Your Ref: OWPC21043
Our Ref: A/158/18/PL 23-11-2018
Please ask for:
Mrs A Gardner

Variation of condition 1 imposed under A/8/18/PL relating to the substitution of approved plan drawings NO ADC 962 04 rev A & 13 rev B for drawings No ADC 962 20 & 21 (ground & first floor plans & roof plan). This application affects the character & appearance of the Angmering Conservation Area.

Land Rear Of 1 To 6 The Cottrells Angmering

Ground Floor Plan @ 1:100

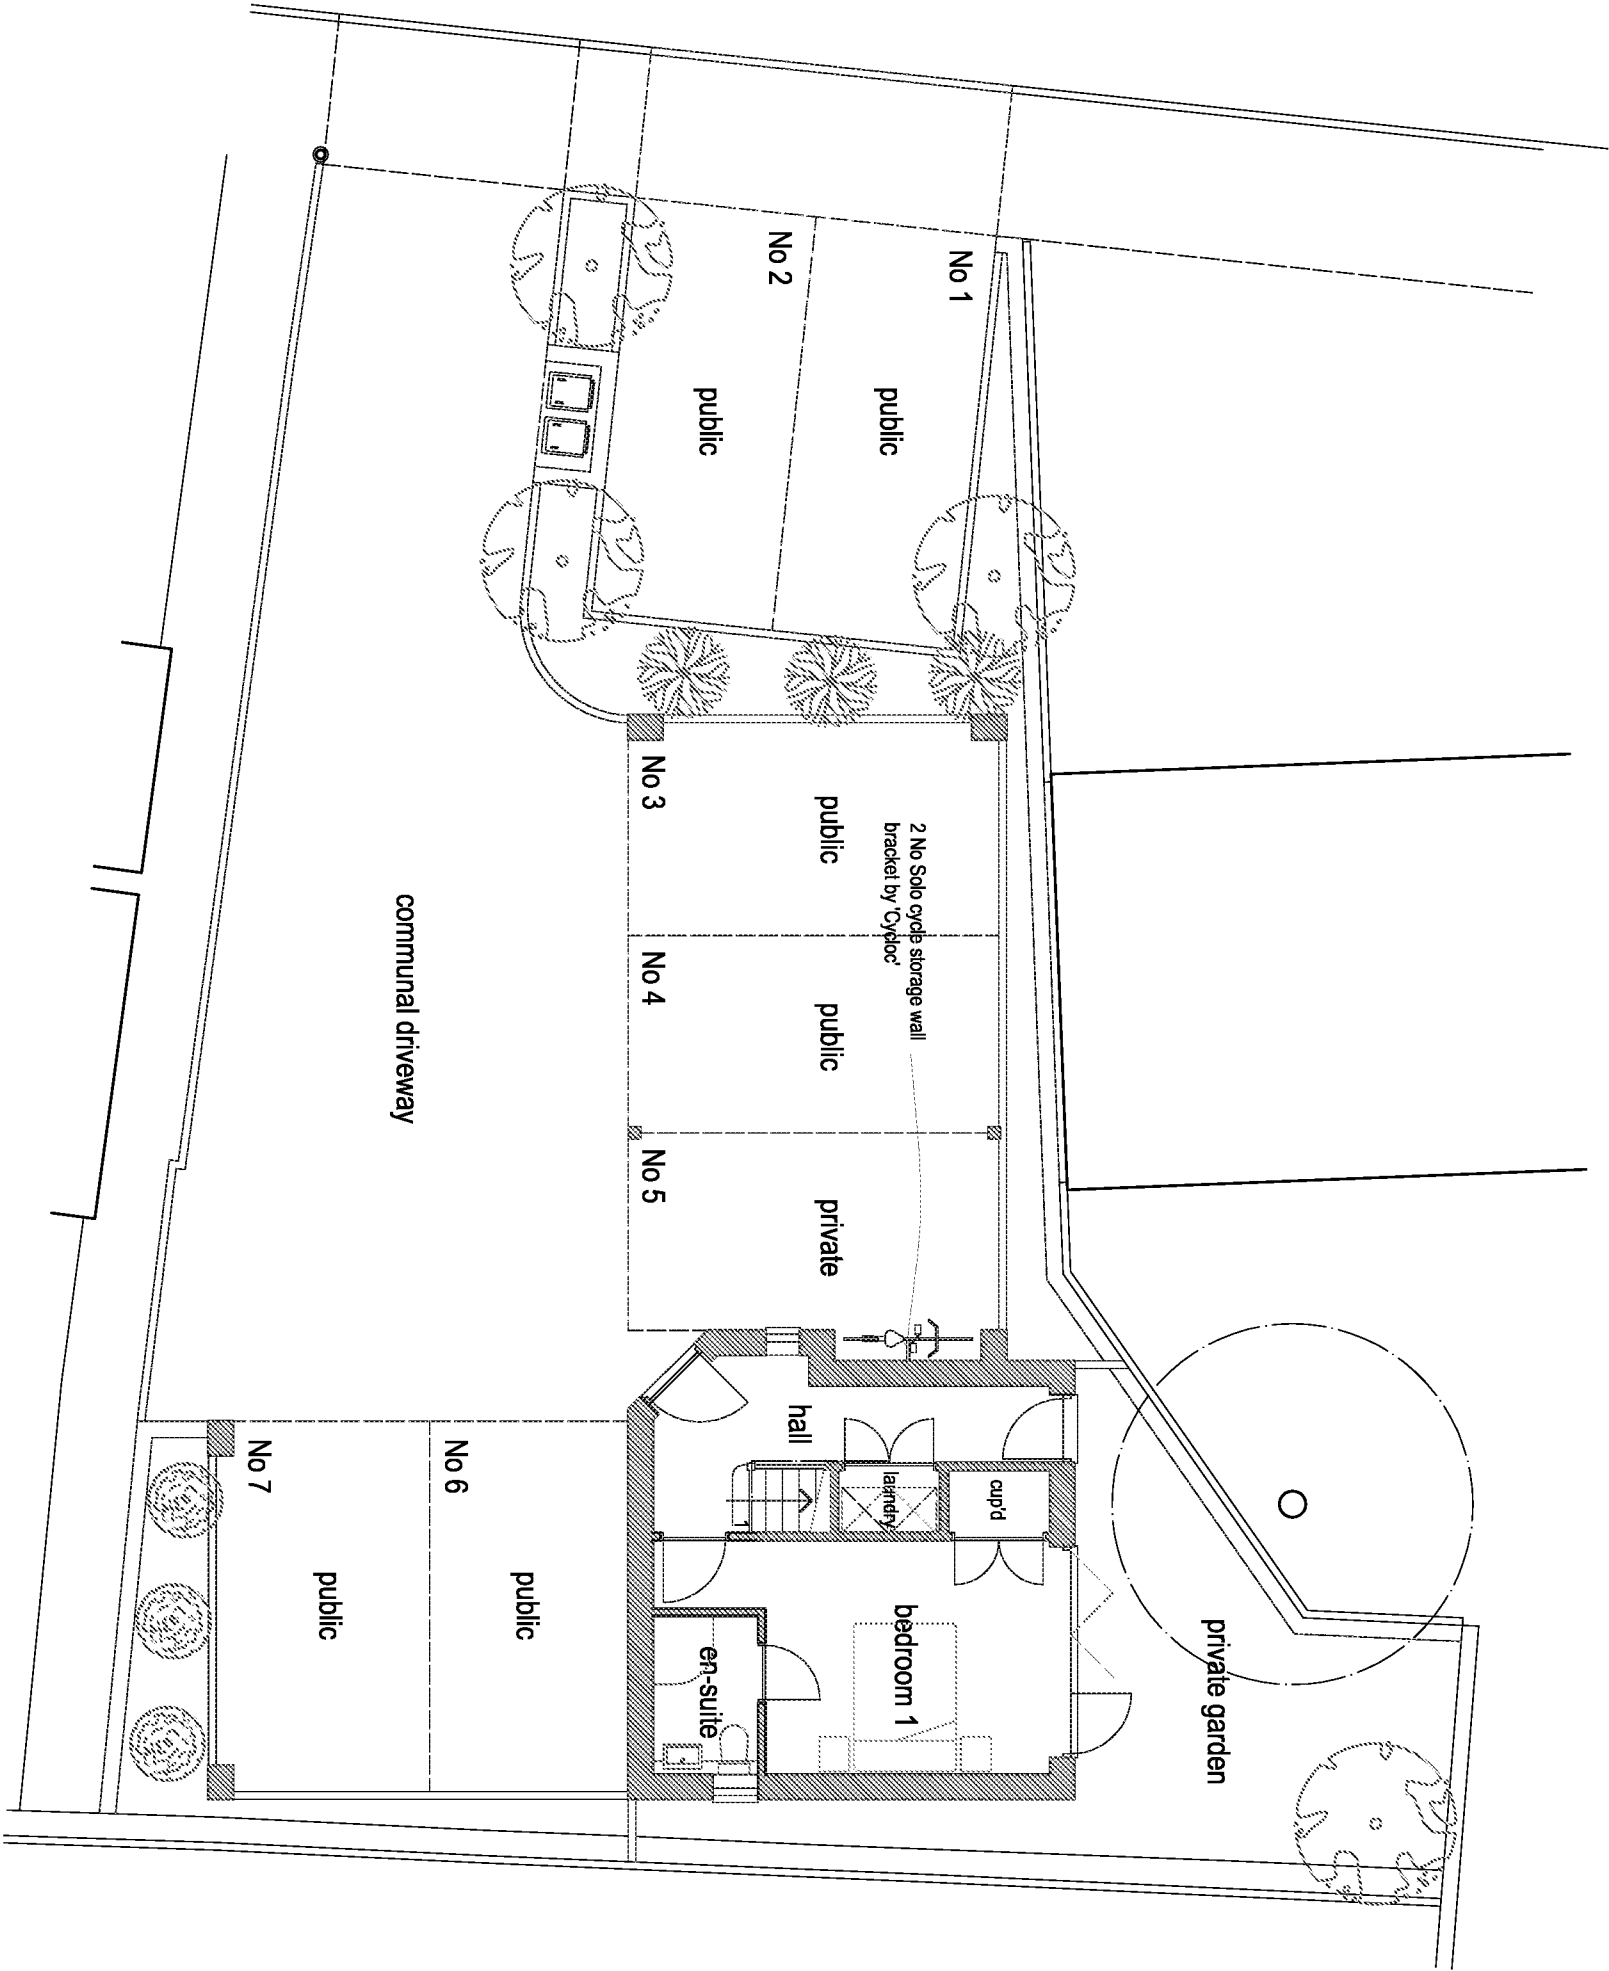
The reclassification of one of the bedrooms as a study in this application when the room is larger than the adjacent bedroom is an attempt to pull the wool over the eyes of ADC's Planning Department. The dwelling has been built as a 3 bedroom property presumably to raise the potential sale value and profit for the developer.

has been built. One possibility may be to request that the study is converted into the bathroom and the bathroom into the study. The smaller room is too small to accommodate a single bed so would ensure that the property could only be used as a 2 bedroom dwelling. The developer cannot argue against the costs associated with this reconfiguration because the layout was built to a rejected design.
